DOC17/599447-01
SSD 8647

SSD 8647 – HORNSBY HOSPITAL RE-DEVELOPMENT – ENVIRONMENTAL IMPACT STATEMENT (EIS)

- ENVIRONMENT PROTECTION AUTHORITY COMMENTS – HORNSBY HOSPITAL RE-DEVELOPMENT STAGE 2 EIS

APPENDIX 1 – NOISE MONITORING ALONG BURDETT STREET

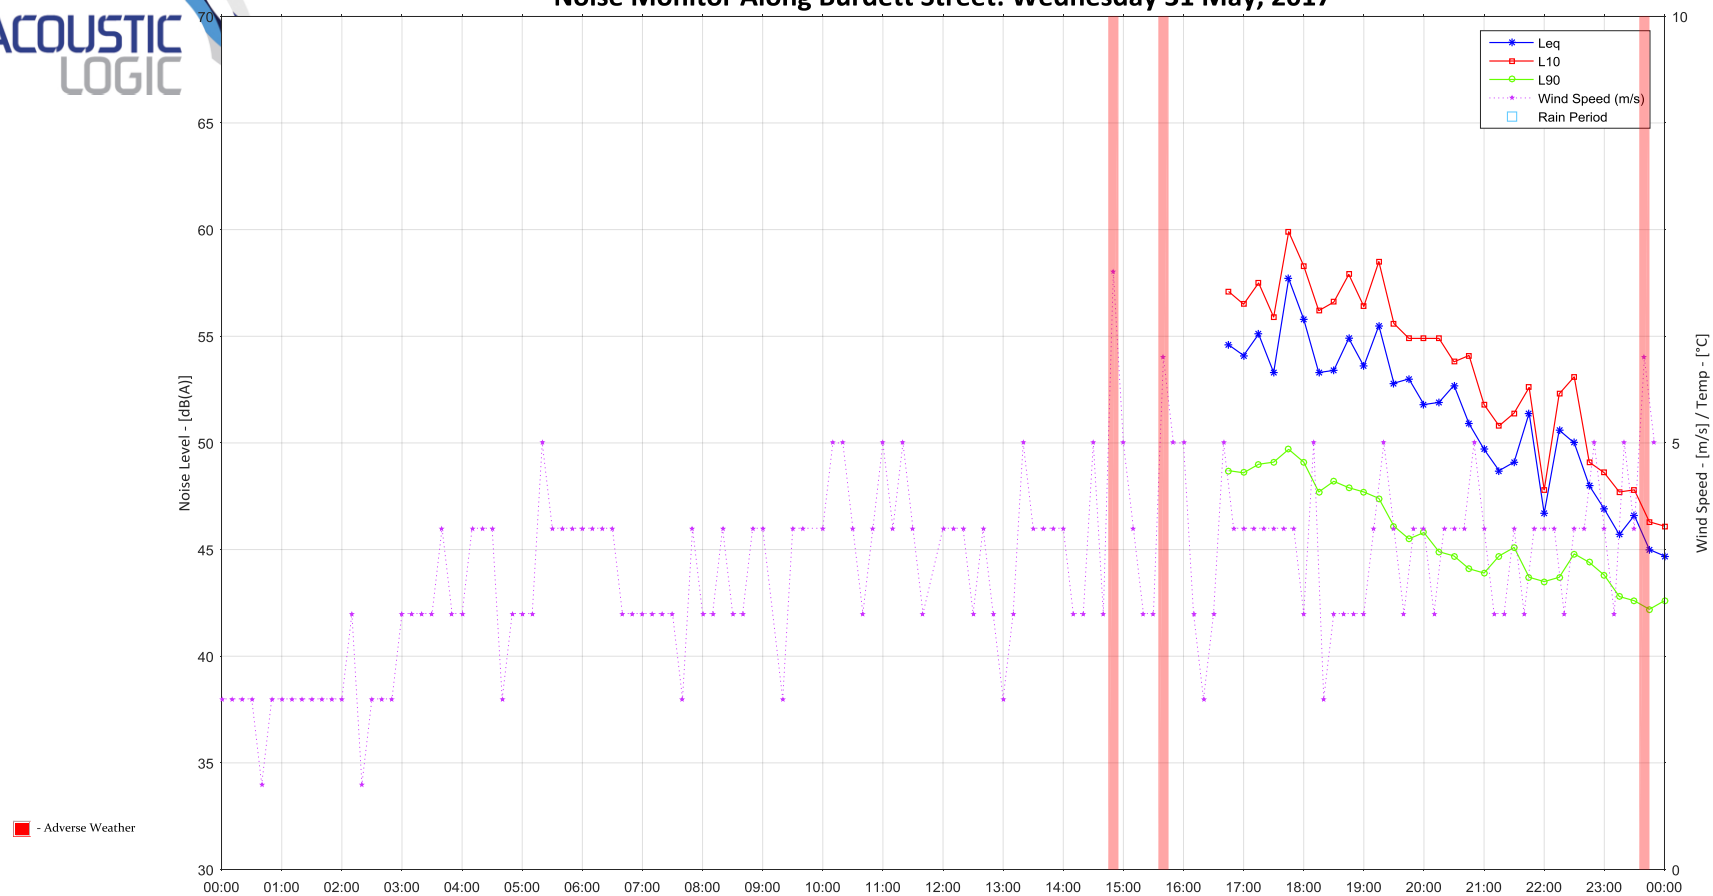
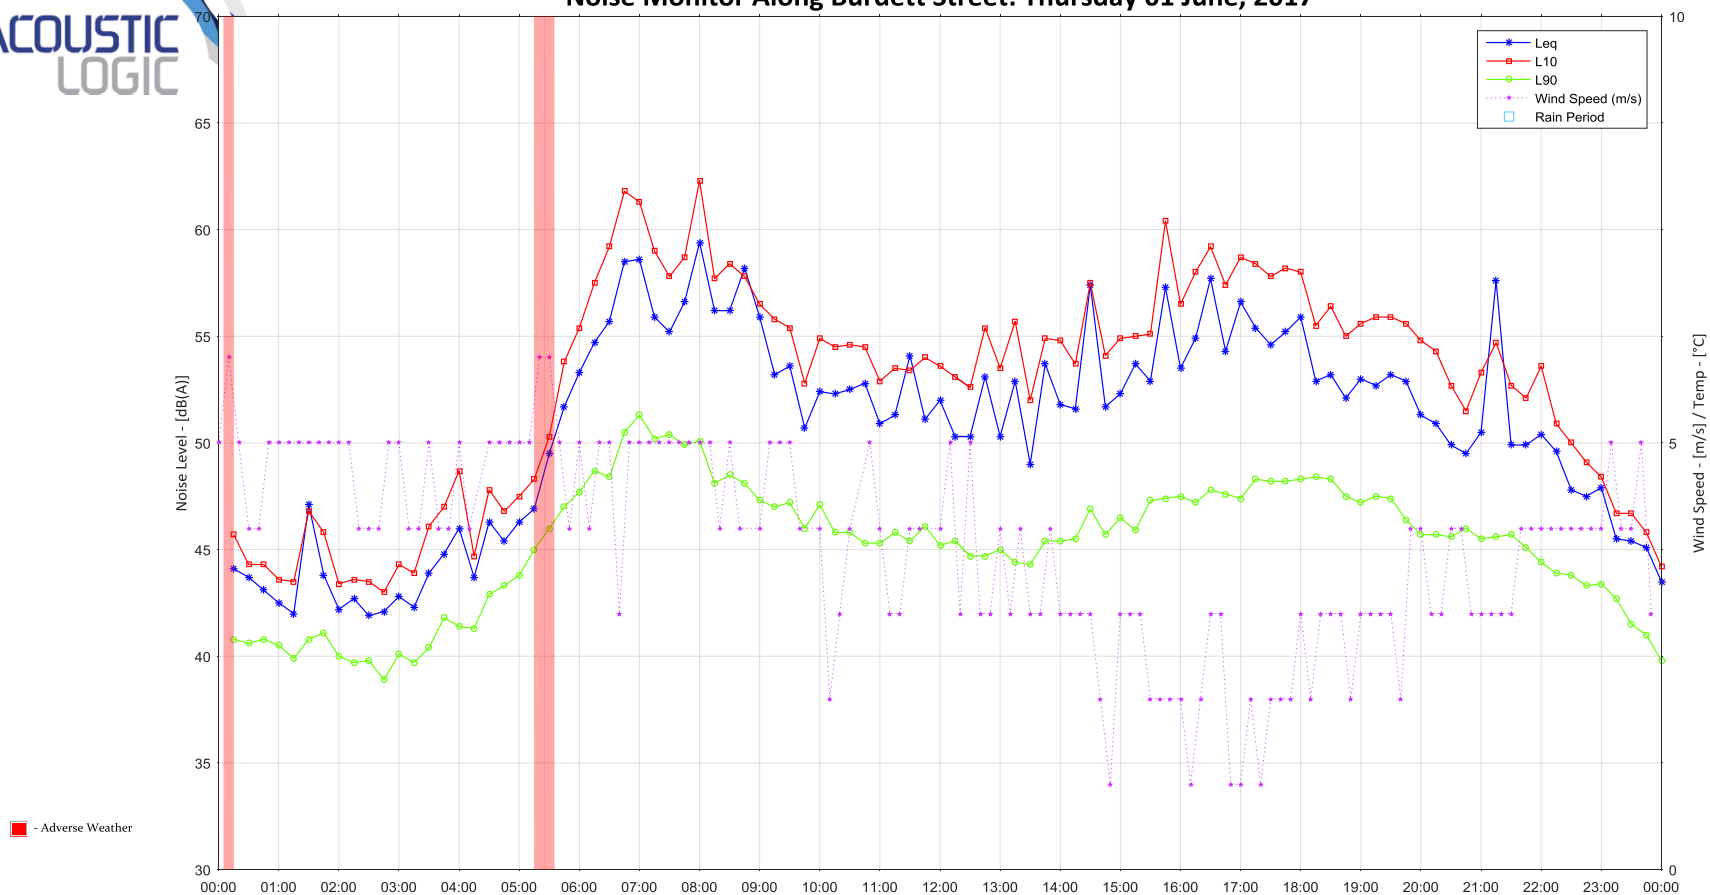
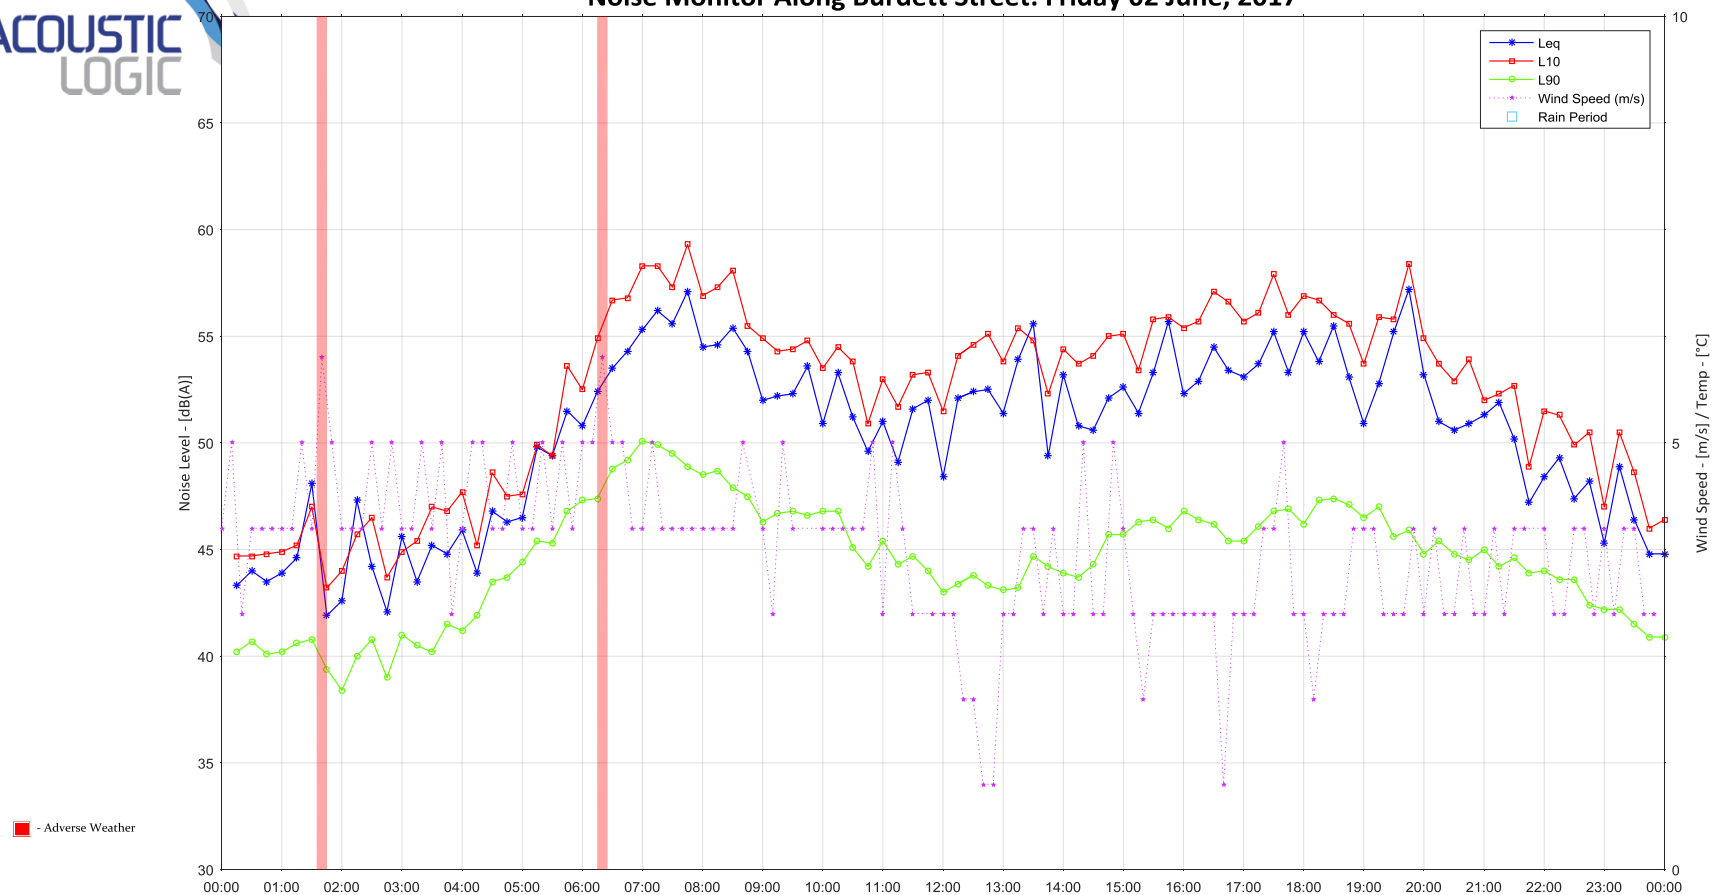
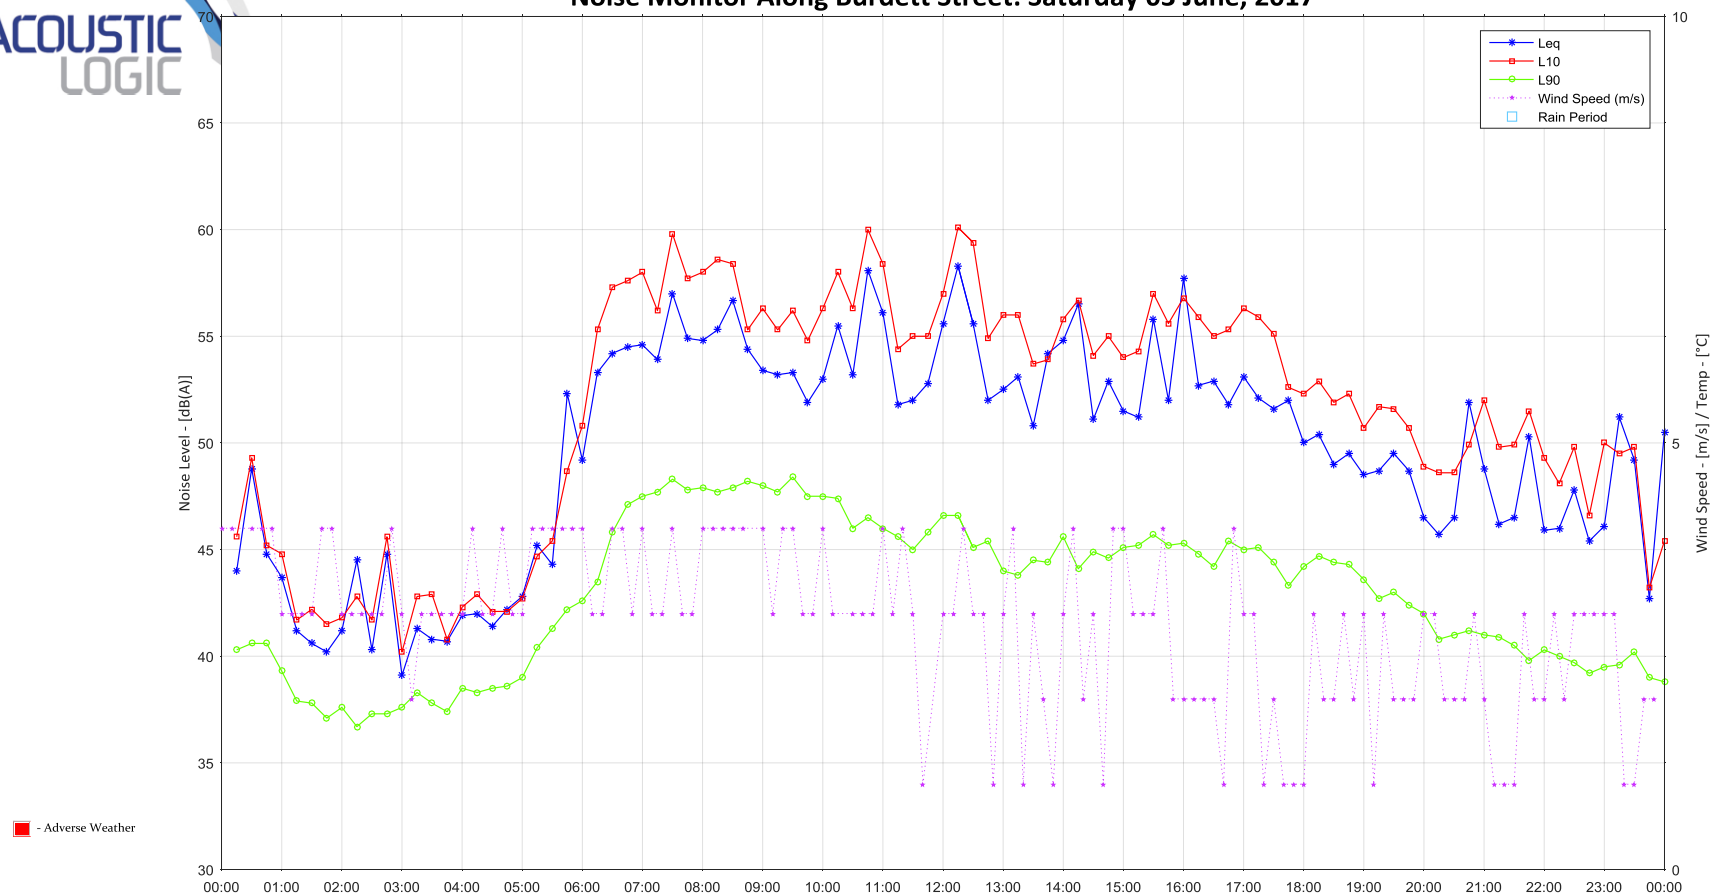
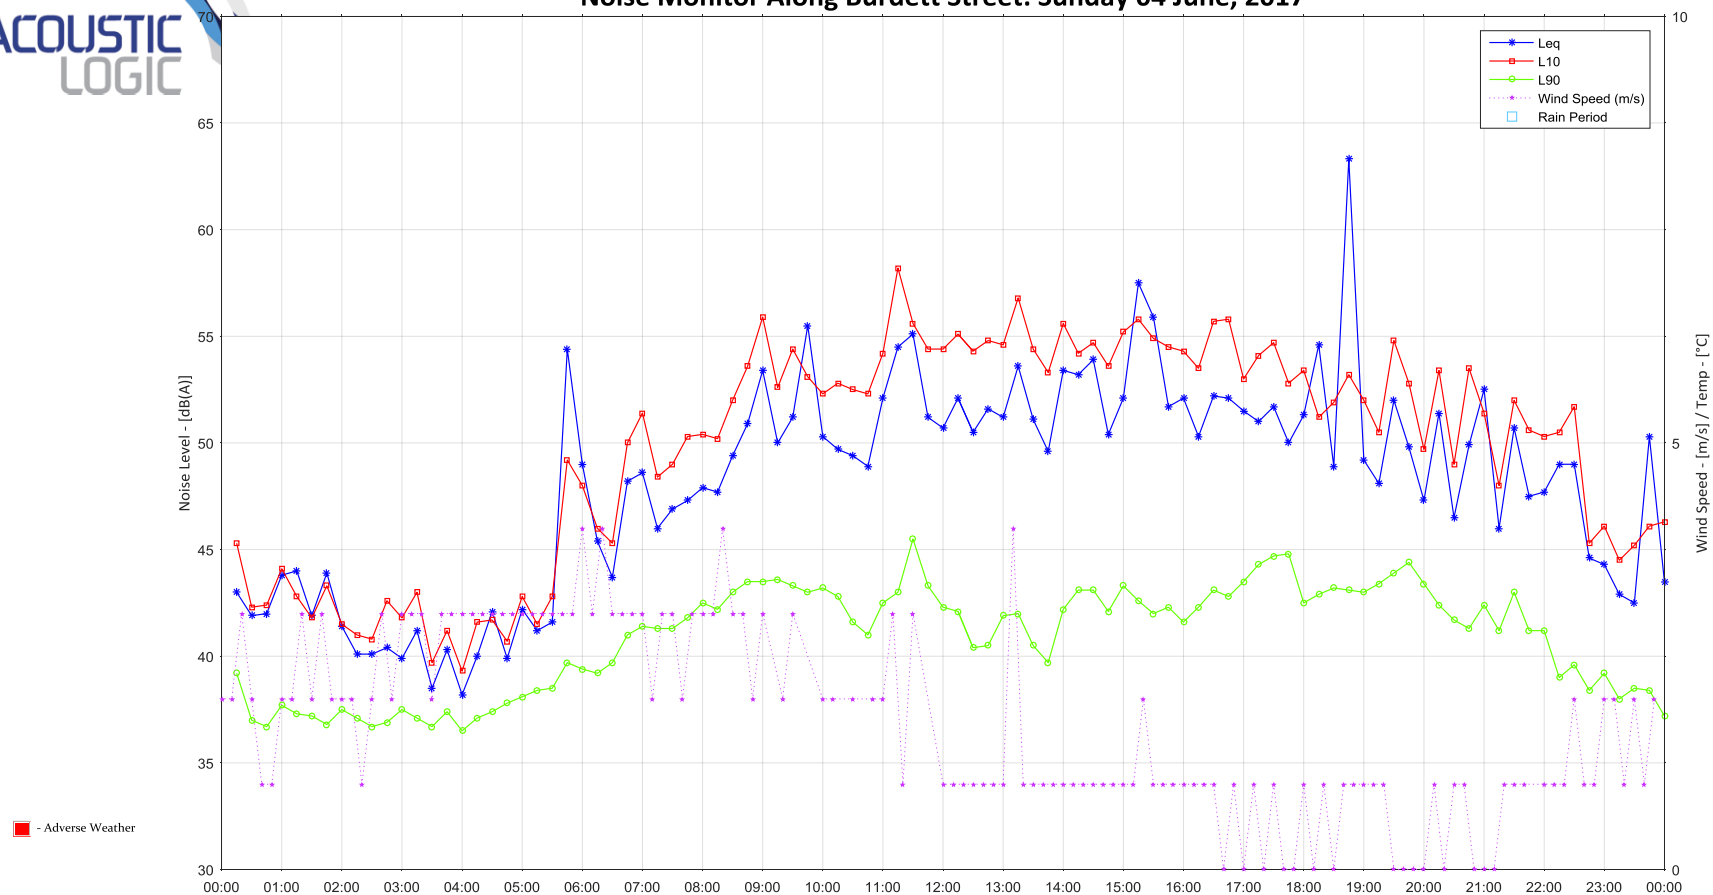
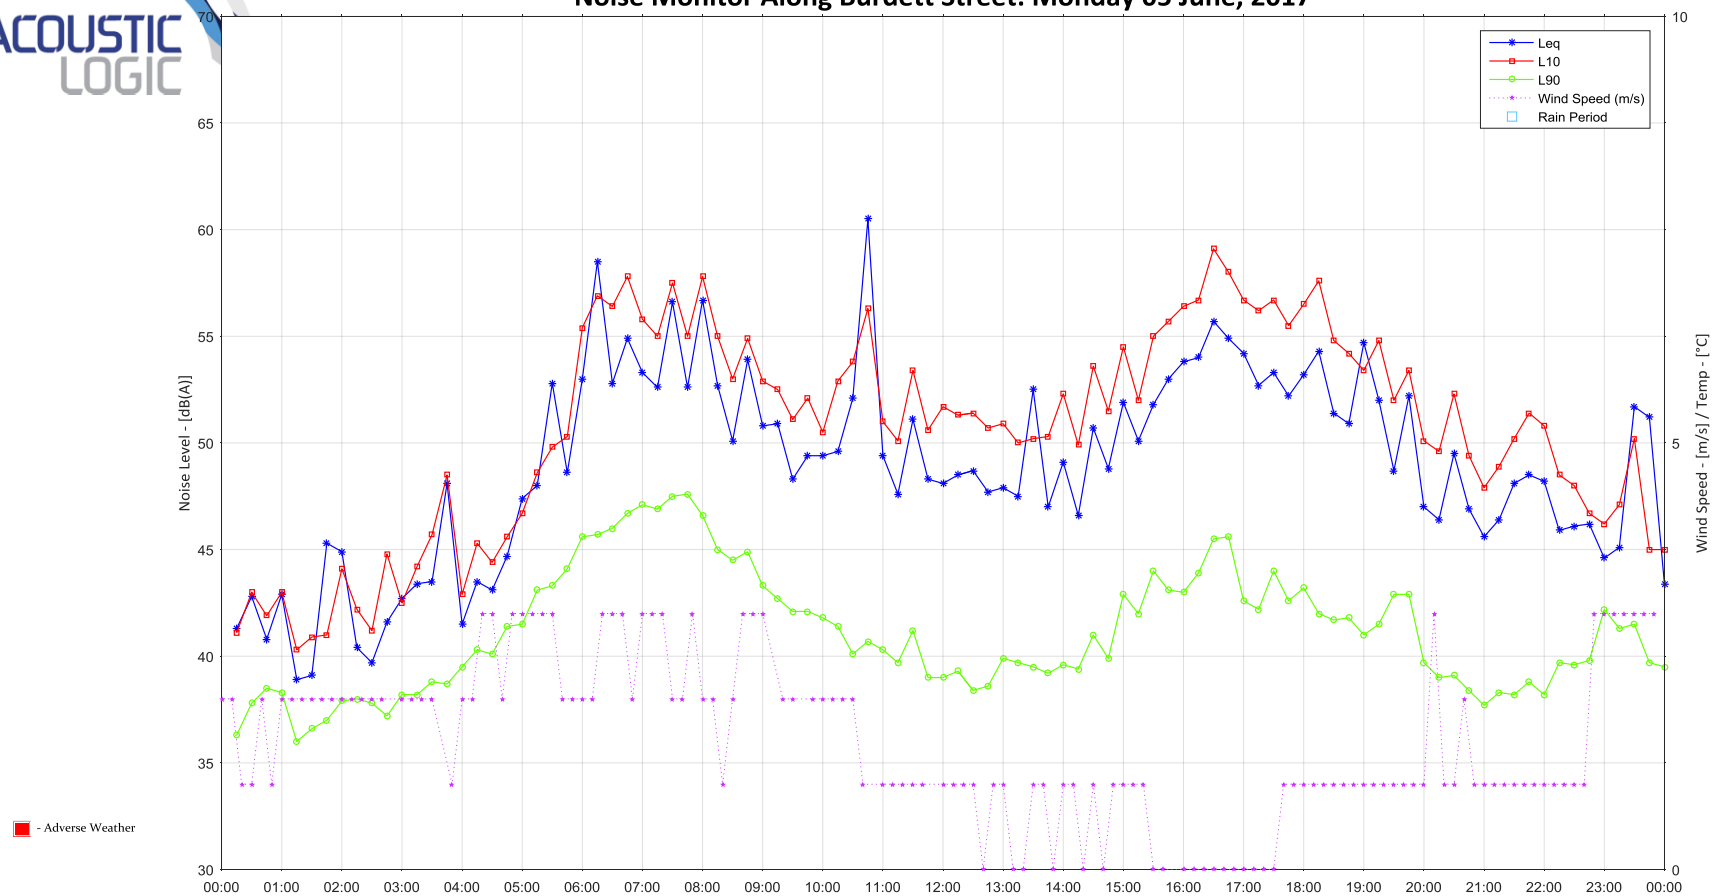
Section 4.1 to Appendix Q states that "[o]n review of the monitoring data, the measured L_{90} noise levels during high wind speed days generally do not increase background noise level significantly". The EPA considers the foregoing statement to be inaccurate for the graphs presented of the Burnett Street data, which show exactly the opposite for the evening of 6 June and all the data for 7 June.

The EPA is further concerned that in respect to the background noise monitoring graphs appended to EIS Appendix Q –

- (a) the legends to some monitoring graphs appear to be misaligned (e.g. wind speed, rain period),

- (b) the legends to monitoring graphs includes a blue marker for 'rain period' and although rain was observed on several days during the various monitoring periods (i.e. 24 May to 7 June 2017), no rain periods are represented in the graphs, and
- (c) some of the monitoring graphs include sections of red highlight, but there is no red marker in the legend to those graphs to identify the meaning of those red highlighted periods, and
- (d) Appendix Q does not appear to identify when noise monitoring loggers were last laboratory calibrated which brings into question reliability of the recorded data.

- (a) the equivalent of a week's worth of valid data, measured at the potentially most affected noise sensitive receiver locations in Burdett Street, Derby Street and Palmertson Road; and
- (b) the results of attended monitoring, graphical results of unattended monitoring with a complete and accurate legend together with a table of assessment background and daily ambient levels.
